From: [REDACTED]
Sent: 25 April 2018 16:13
To: Planning
Cc: [REDACTED] Cllr. Paul Bicknell; Cllr. Andy Cooper; Cllr. Dudley Wensley
Subject: A/38/18/RES Manor Nursery, Angmering

Please find attached Objection to planning application
A/38/18/RES Manor Nursery, Angmering.

Whilst accepting the principal of development on the Manor Nursery site, SAV strongly **OBJECTS** to elements of this application. Specifically, in respect of the proposed main access route to the development via the High Street. The issues highlighted below have already been noted in the previous application A/51/14/OUT for this site, but in our view, have been ignored by the developer.

3.13 ACCESSIBILITY

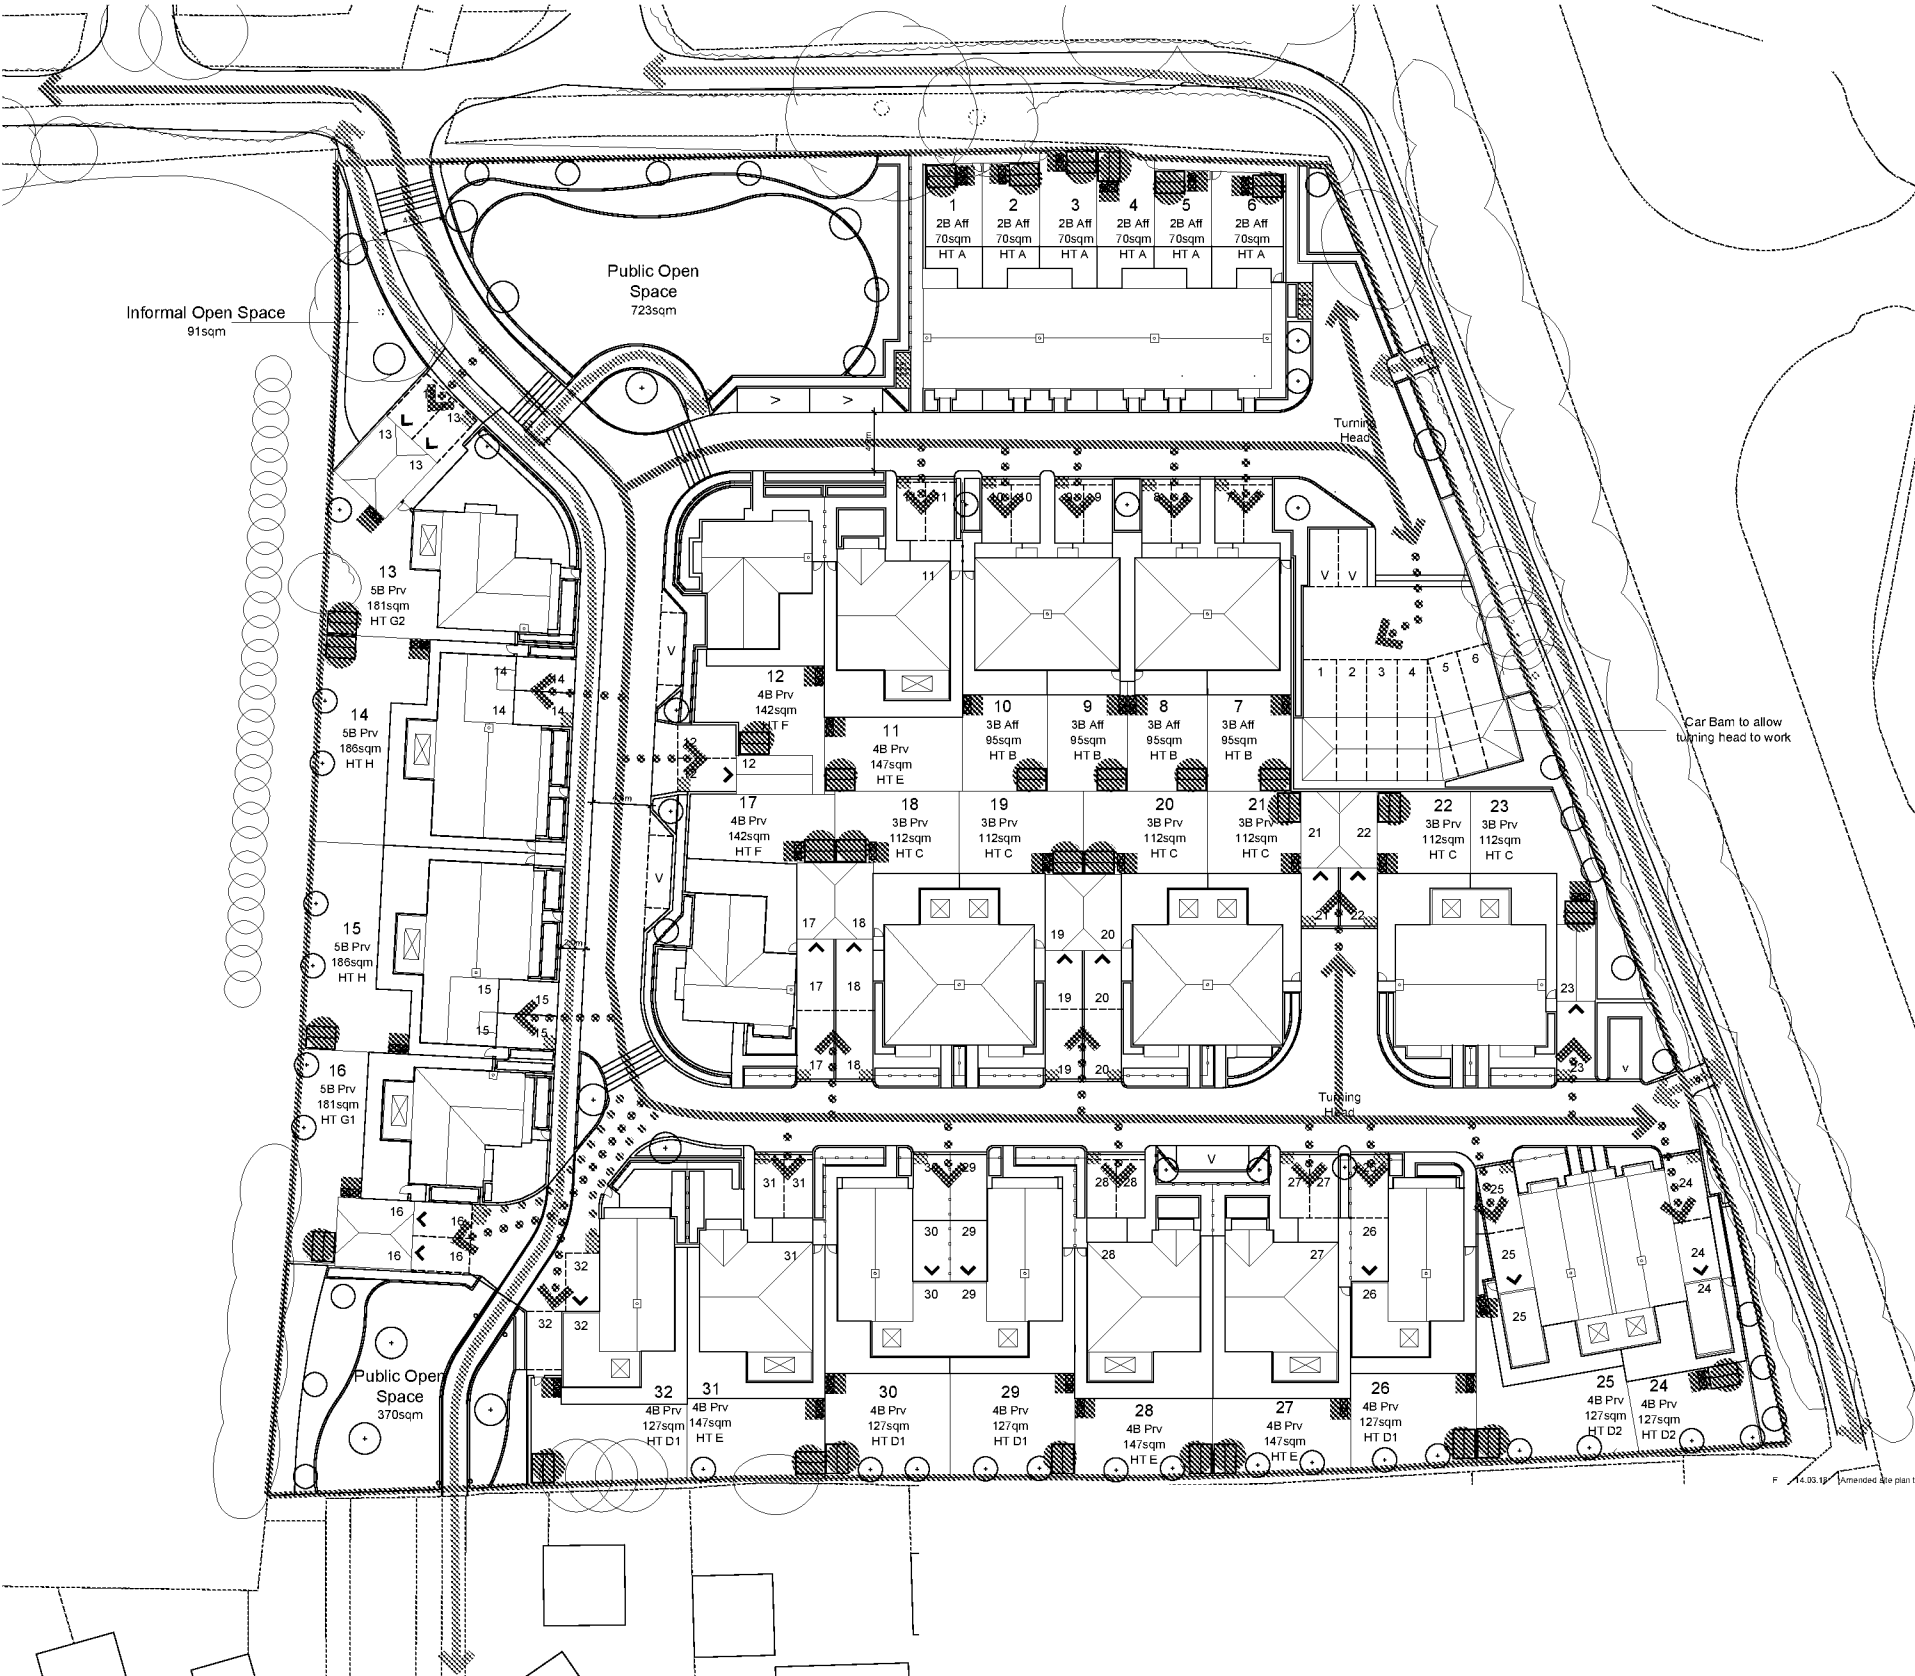
Main Access via the High Street:

The proposed change to High Street clearly impacts upon the amenity value and safety of current users, urbanises the setting of the Conservation Area, and has

Transport Note: The additional detail provided by the applicants "Transport Note" concentrates on highway safety within the curtilage of the site itself. The proposal does not consider the current role performed by the High Street, or the implications to the safety of current non-motorised users that will have to negotiate these unacceptably narrow footpaths.

Status	DRAFT		Scale	1:250 @ A1
Drawn	BC	Checked	MS	Date APRIL 2014
Drawing Number	033/01			Revision A

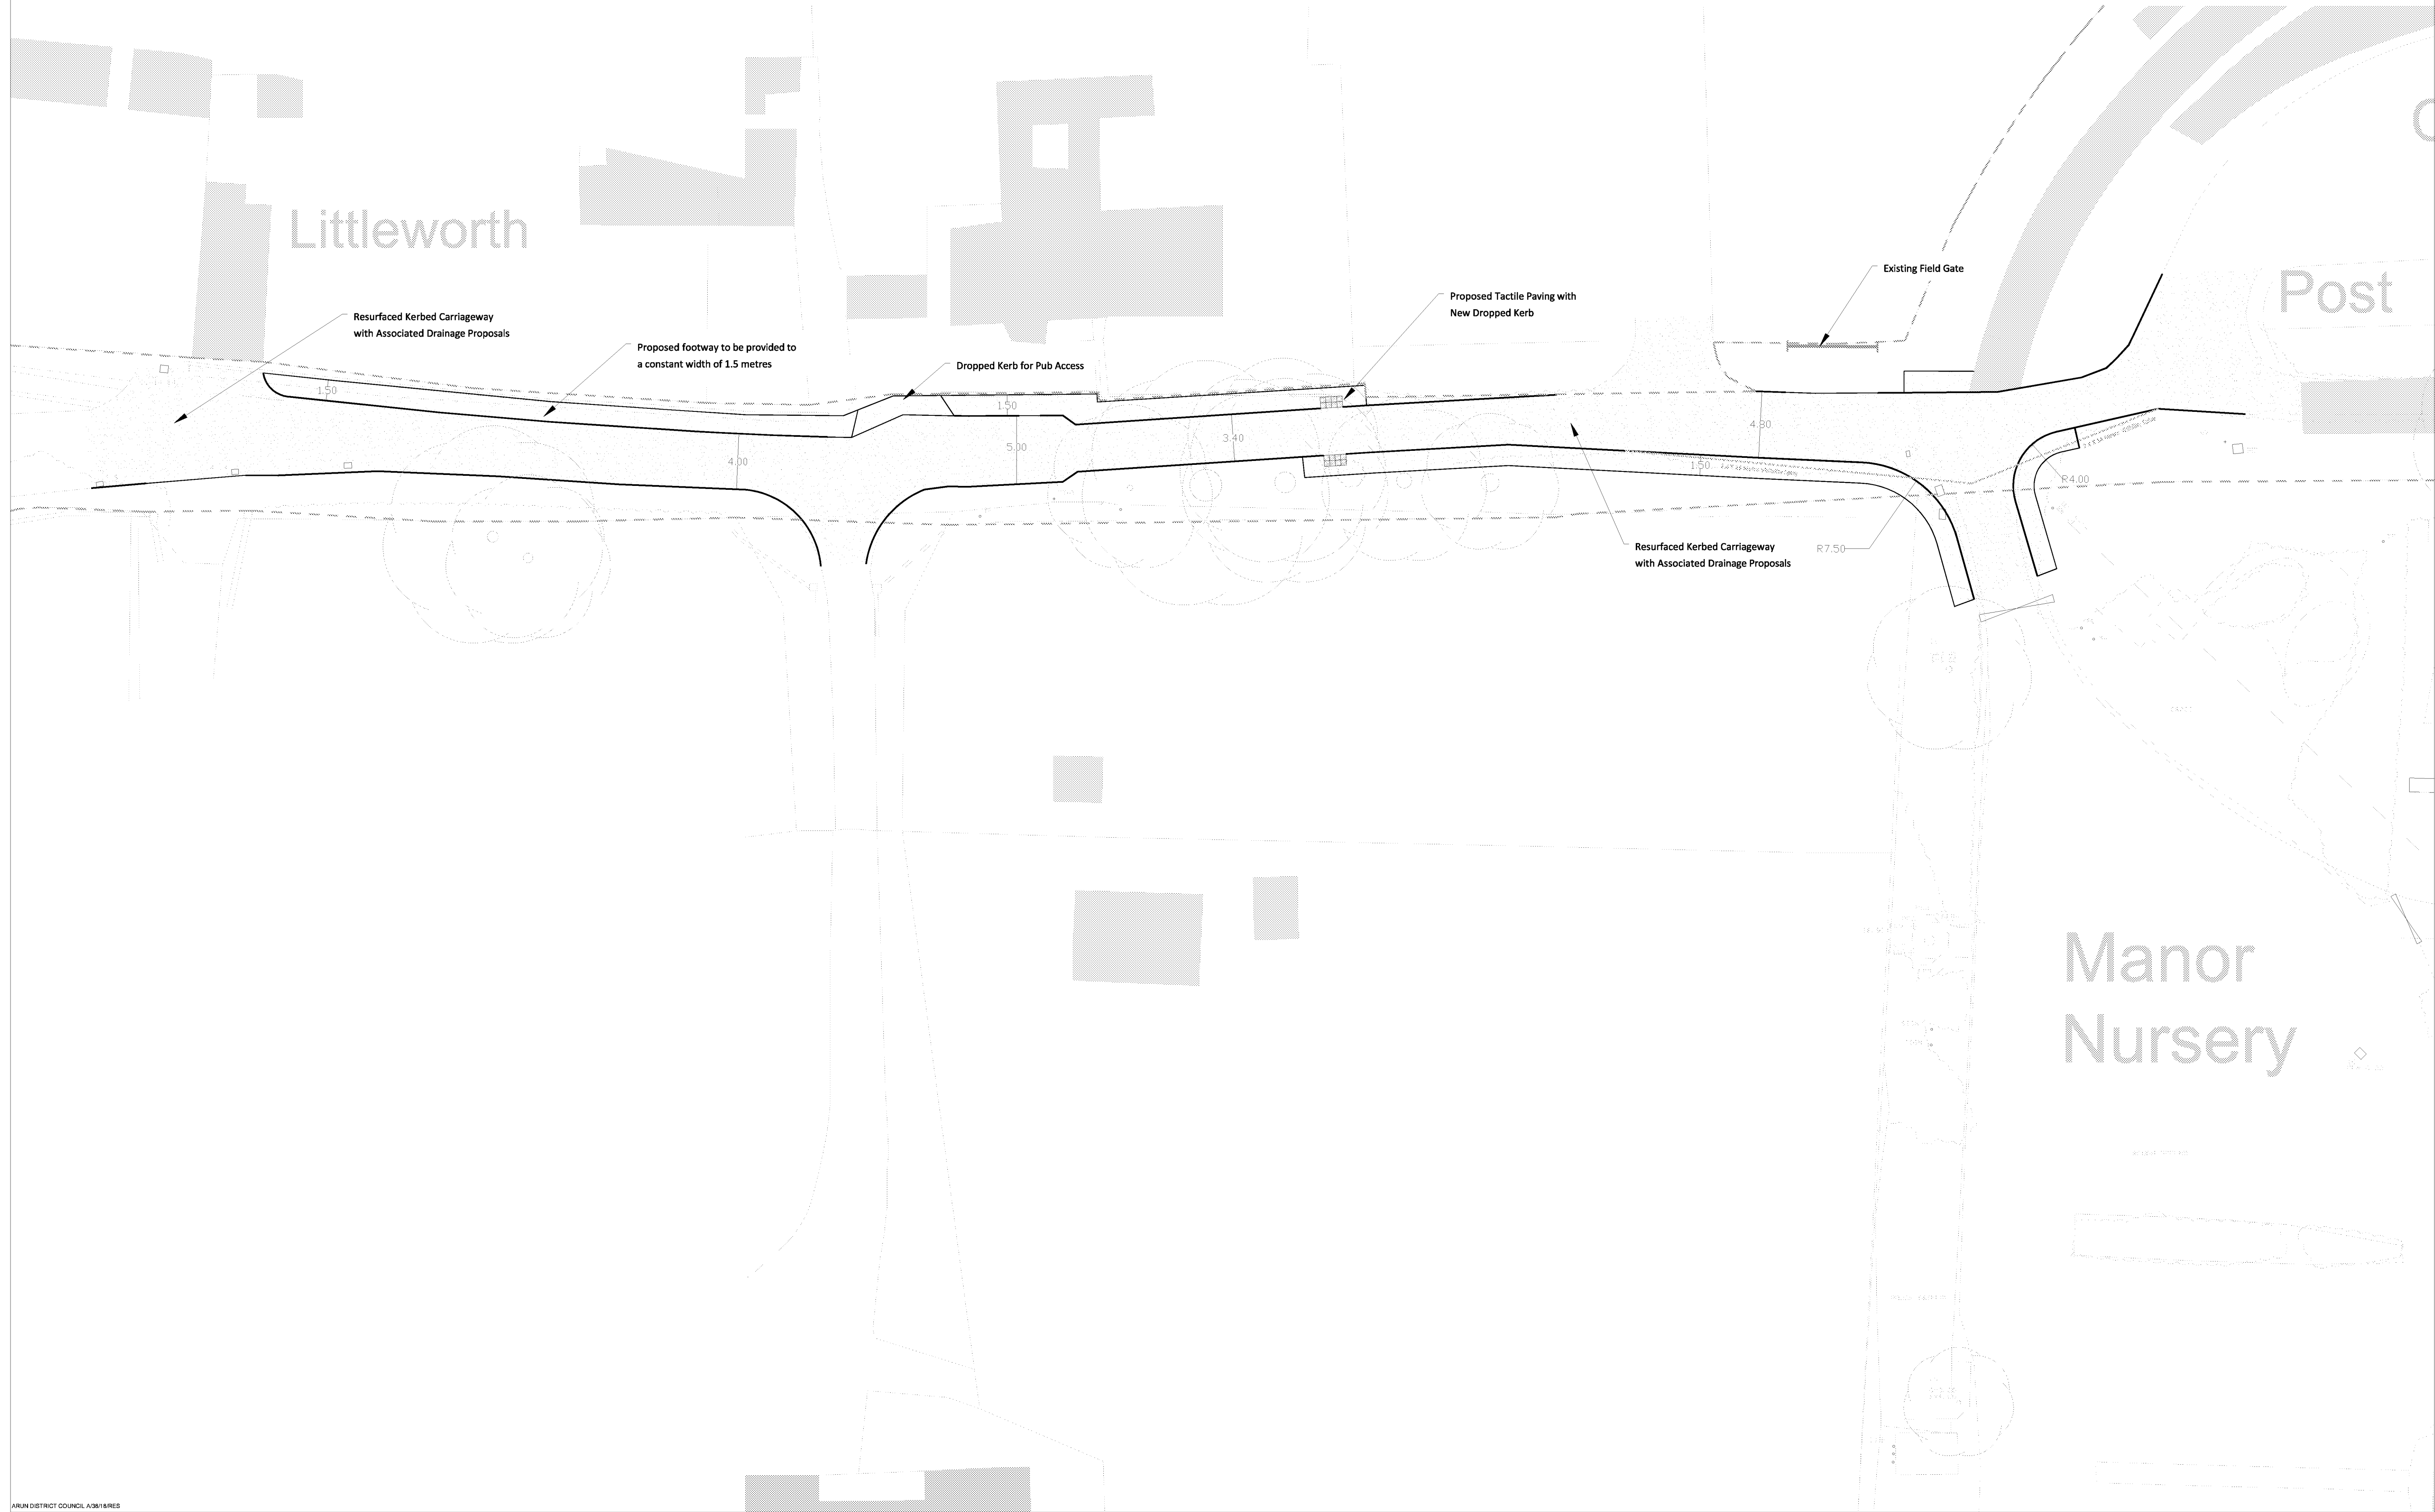
The introduction of footpaths between 1000mm and 1500mm wide are of specific concern relating to the safety of pedestrians and other types of non-motorised users when considering the current use of this rural lane.

Inadequate Footways and footpaths: The latest plan provides additional detail on the widths of the proposed footpaths along High Street which clearly do not provide satisfactory standards of access for all users.

The applicant does not explain or give any reasons why the width of the proposed footpaths along the High Street are significantly less than that recommended by national guidelines, especially when you take into account that in most cases they are bounded on one side by walls or hedgerows, not verges which provide users with additional "elbow room".

The proposed design does not provide this. Instead, the current amenity value of the High Street will be irrevocably degraded by the proposed introduction of a "restricted" footpath width of between 1500mm and 1000mm, which compromise safety by not only requiring users to walk single file or step into the road to pass each other, but is not continuous and means users will have to cross and re-cross the road along its length.
